Planning Application Ref: R/197/20/OUT

Location: Croft Works, 52 Mill Lane, Rustington, BN16 3JN

Description of works: Outline application with some matters reserved for the demolition of existing dilapidated storage buildings & erection of 2 No. detached 3-bedroom chalet bungalows with associated car barns, gardens, car parking & landscaping (resubmission following R/117/20/OUT).

Mark Warwick
Tree Officer / Parks and Greenspace Team

SITE PLAN 1:250

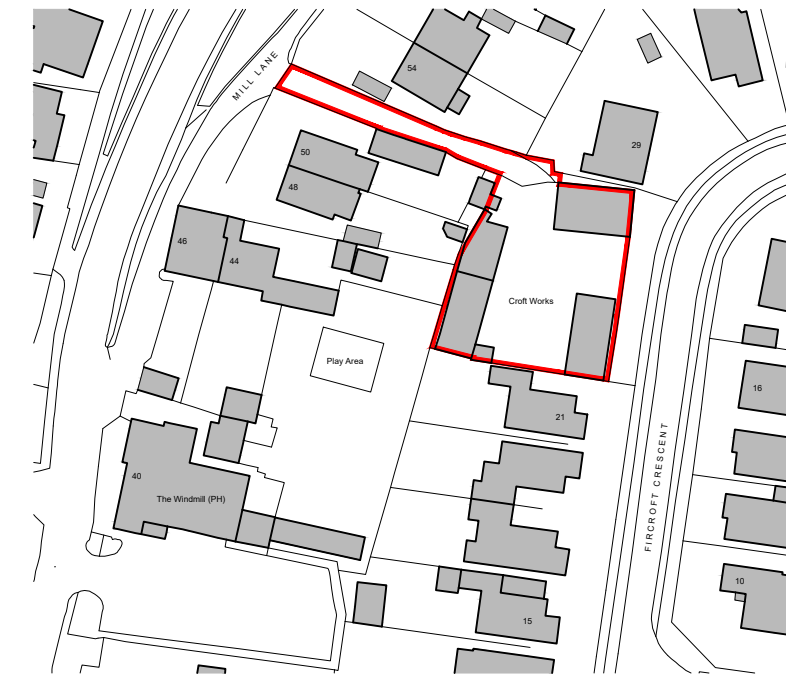
- Drainage and service-runs in and out of site have not been shown so there is potential for root protection area incursion to satisfy those requirements.

1. The applicants will need to employ the services of an Arboricultural Consultant to carry out a tree survey exercise and then prepare an Arboricultural Impact Assessment (AIA) which must be inclusive of; a 'Tree Survey Schedule', a 'Root Protection Area (RPA) Schedule' and a 'Tree Constraints Plan' – with the trees accurately plotted on same.
2. In the event that a RPA of any tree which is proposed for retention overlaps the development then BS5837:2012 requires that the Detailed Planning Application is accompanied by an Arboricultural Method Statement (AMS) and also most importantly a Tree Protection Plan – to both describe and illustrate the mitigation measures which are to be employed to ensure that the trees survive without detriment to their vigour and vitality and are given adequate protection both above and below ground.
